STATE OF NORTH CAROLINA  
DEPARTMENT OF TRANSPORTATION

Subject: **NCDOT Response to Request for Additional Information Dated April 22, 2019, and subsequent Application Modification** for the Widening of US 70 from Mt. Hope Church Road to Sun Lake Road in Guilford County. NCDOT Division 7, TIP No. U-2581 BA, WBS 34840.1.4.

PERMIT DRAWING
SHEET 3 OF 14

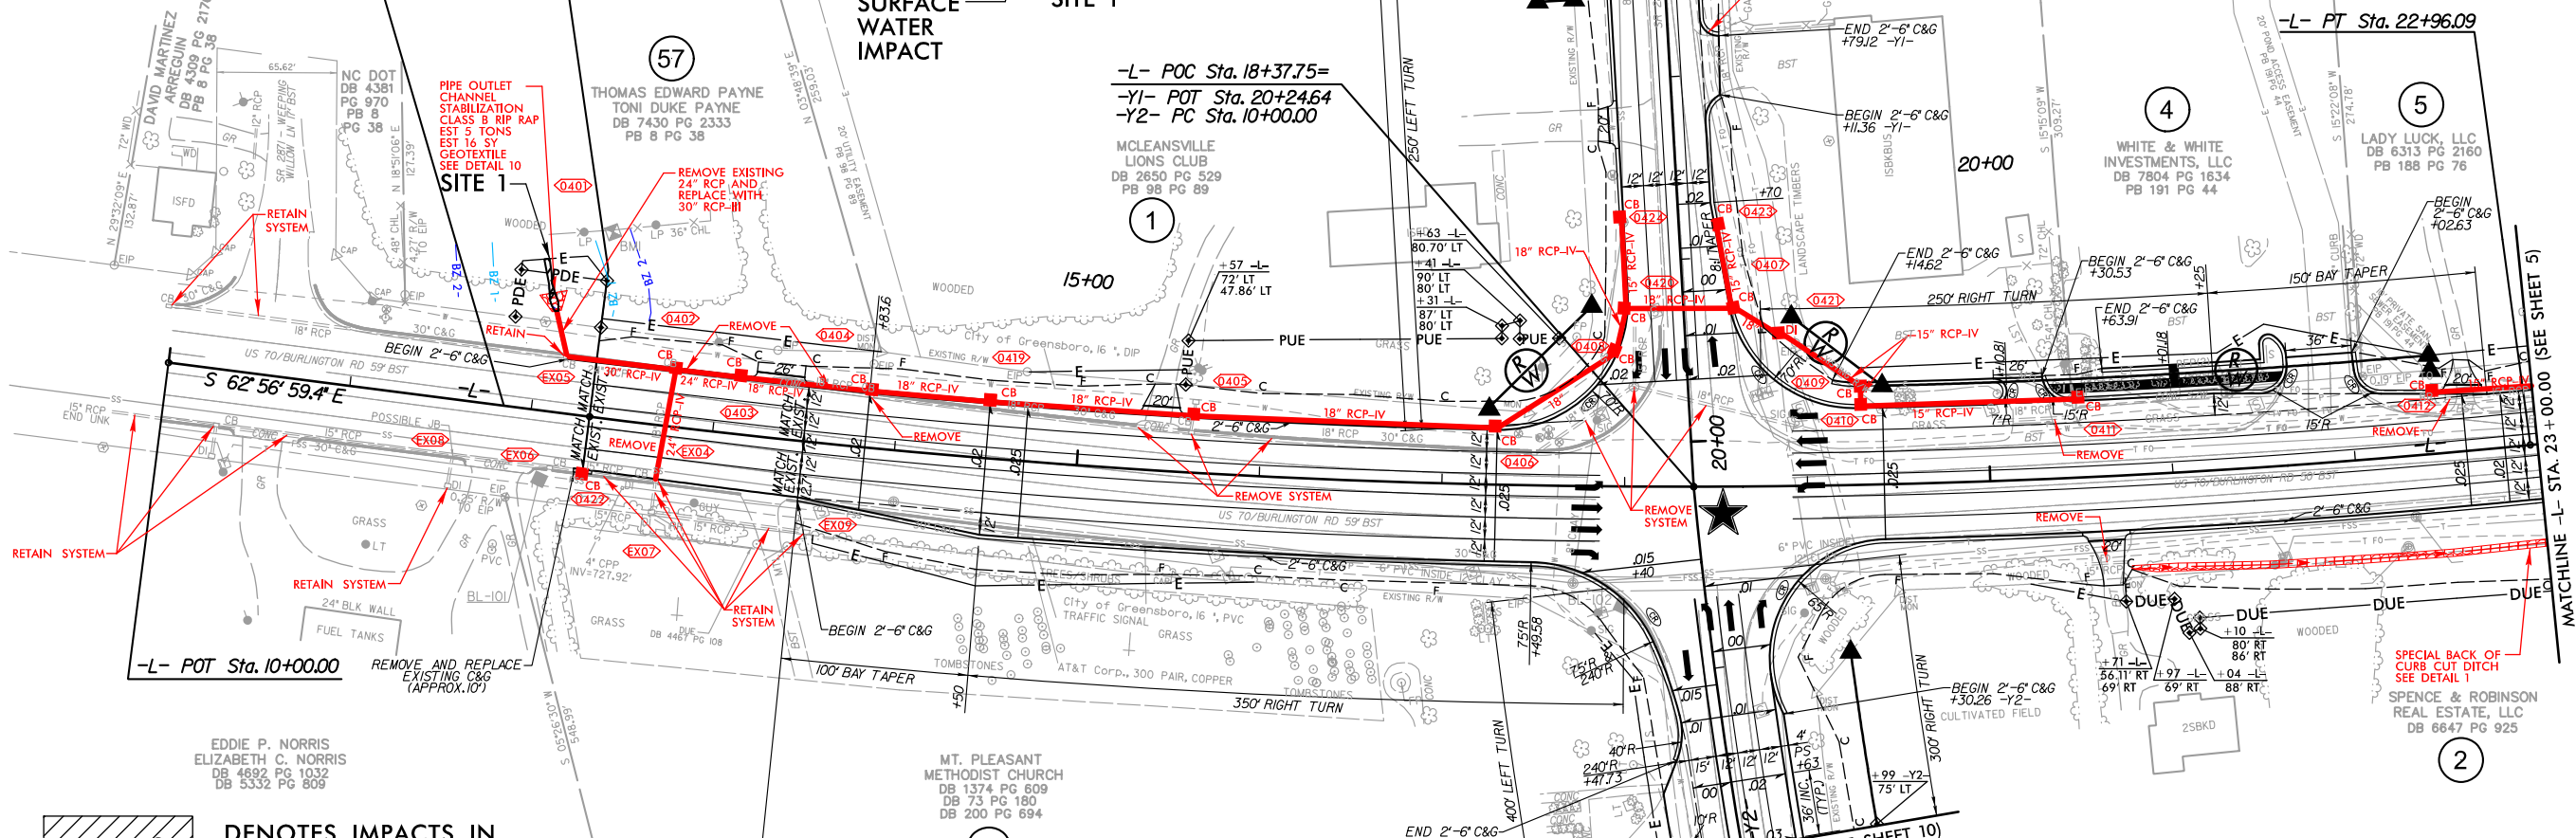
**Site 1**

Detail 10 was added to display the cross section of the stabilization impact at the pipe outlet. The rip-rap will be "keyed-in" to stabilize the system, but not impede aquatic passage.

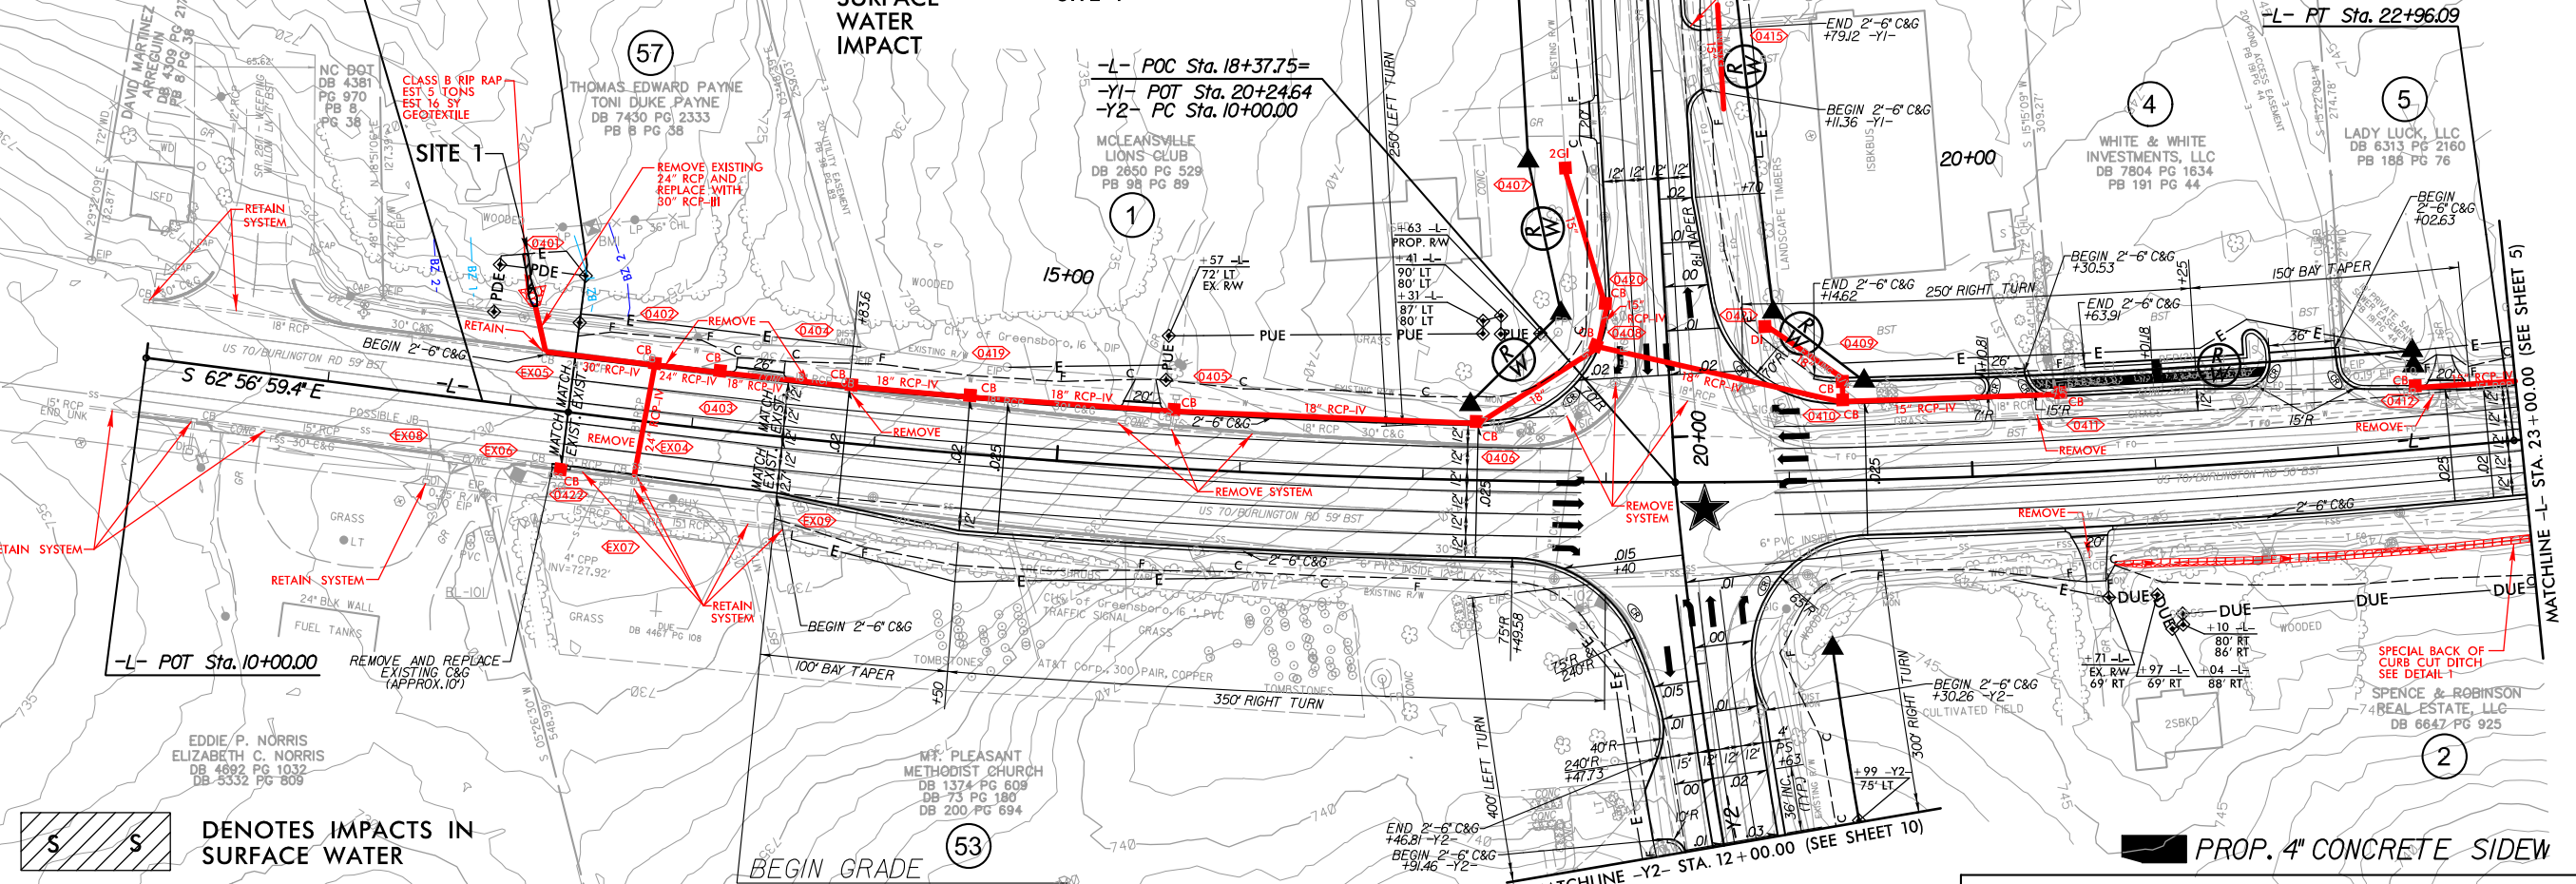
**Site 3**

Detail 10 was added to display the cross section of the stabilization impact at the pipe outlet. The rip-rap will be "keyed-in" to stabilize the system, but not impede aquatic passage.

While re-reviewing Site 3, the engineer increased the size of the rip rap at this location. This increased the permanent impact from 11 to 13 feet, and decreased the temporary impact from 16 to 13 feet.
